**KIRKLEES METROPOLITAN COUNCIL
INVESTMENT & REGENERATION SERVICE**

Reference No:	2024/62/91243/W
Site Address:	Land at Nabbs Lane, Slaithwaite, Huddersfield, HD7 5AU
Description:	Erection of one dwelling (within a Conservation Area)
Recommending Officer:	John Holmes

Officer Report – 2024/91243

Proposed South Elevation - 1:100

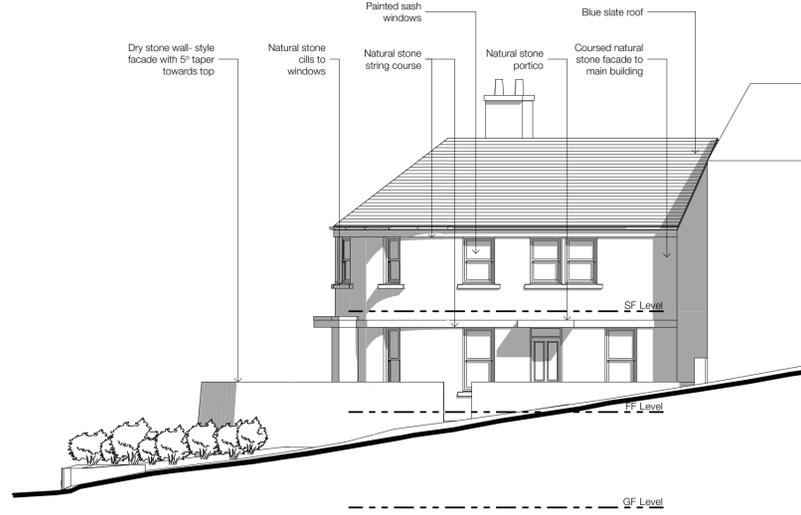
However, the single storey flat roofed element to the front of the site is considered to create a feature which has an overly domineering and has a significant impact in relation to the setting of the site within the Conservation Area, and also the visual amenity of the proposed dwelling and wider locality. The height of this element of the proposal is 4.3m when measured from Nabbs Lane and would be around the corner of the site (albeit of lesser height when adjacent to the highway) around half of the southern part of the boundary and part of the eastern boundary.

The expanse and massing in such proximity to the highway is considered to negatively impact upon the character of this part of the street. Whilst historically there was a building on this site, this has been removed and this site has been open and free from built form for a considerable time.

The design is such that the dwelling would appear obscured from view when observed from the south / east of the site with a high wall which would have an imposing appearance within the street. Furthermore, the flat roof element to the front would see the only area of amenity space within a raised position on the prominent part of the site. Associated activities would be highly prominent and likely lead to pressure for further screening / enclosure of this area from future occupiers, which would have a further significant impact with regard to visual amenity / character of the locality.

However, it is considered the appearance of the proposed dwelling is such that, as a result of the single storey element to front, raised terrace and fenestration details at the first floor level, the proposed dwelling would be out of character with the locality and would lead to a detrimental level of visual harm that would fail to harmonise with the setting of the site. The proposal would lead to less than substantial harm for which no public benefits to outweigh this harm have been identified. The development would be contrary to policies LP24 and LP35 of the Kirklees Local Plan, principles 2 & 14 of the Housebuilder Design Guide SPD and policies within Chapters 12 and 15 of the National Planning Policy Framework.

It is considered that design solutions exist which can mitigate the impact of the identified harm, in this case the flat roof element and incorporation of flat roof features and patio door openings at the first floor level. Specifically these

would include the removal of the flat roof element, with the creation of amenity space at the ground level, incorporation of sash windows to the remainder of the first floor and removal of the first floor patio door and flat roof canopy.

Such amendments would allow for the reduction of the height of the curved wall which is immediately adjacent to the highway, and would enable an area of private amenity space to be provided.

Proposed Ground Floor - 1:100

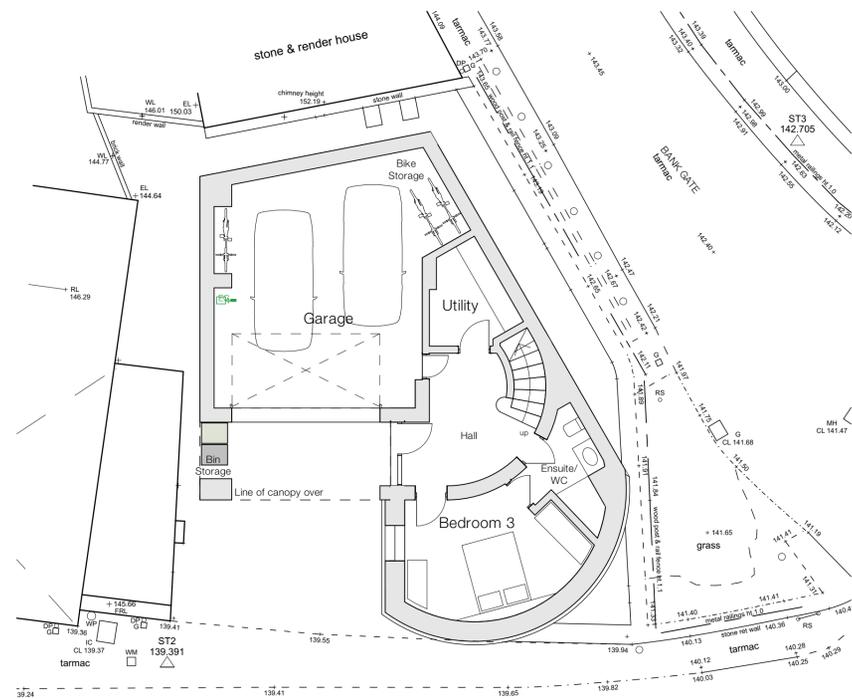
The proposal would provide a 22m² amenity space, at the first floor level, in a prominent location at the front of the site. The level of space provided is somewhat limited given the size of the proposed dwelling and also constraints of the site in terms of its overall size and the access arrangements / need to provide suitable access and parking arrangements.

Notwithstanding this point, whilst a lesser sized level of amenity space may be considered acceptable when balanced against other constraints of the site, it is considered that its provision in a prominent section of the site and at the first floor level is such that the development would not lead to a development which has an acceptable amenity space provision for occupiers of the dwelling.

It is considered that a design solution is possible in this case which could provide amenity space at the ground level, with a suitably sized wall (or wall and railing boundary treatment) to the southern / eastern boundary to provides a level of screening which ensures the amenity space is private.
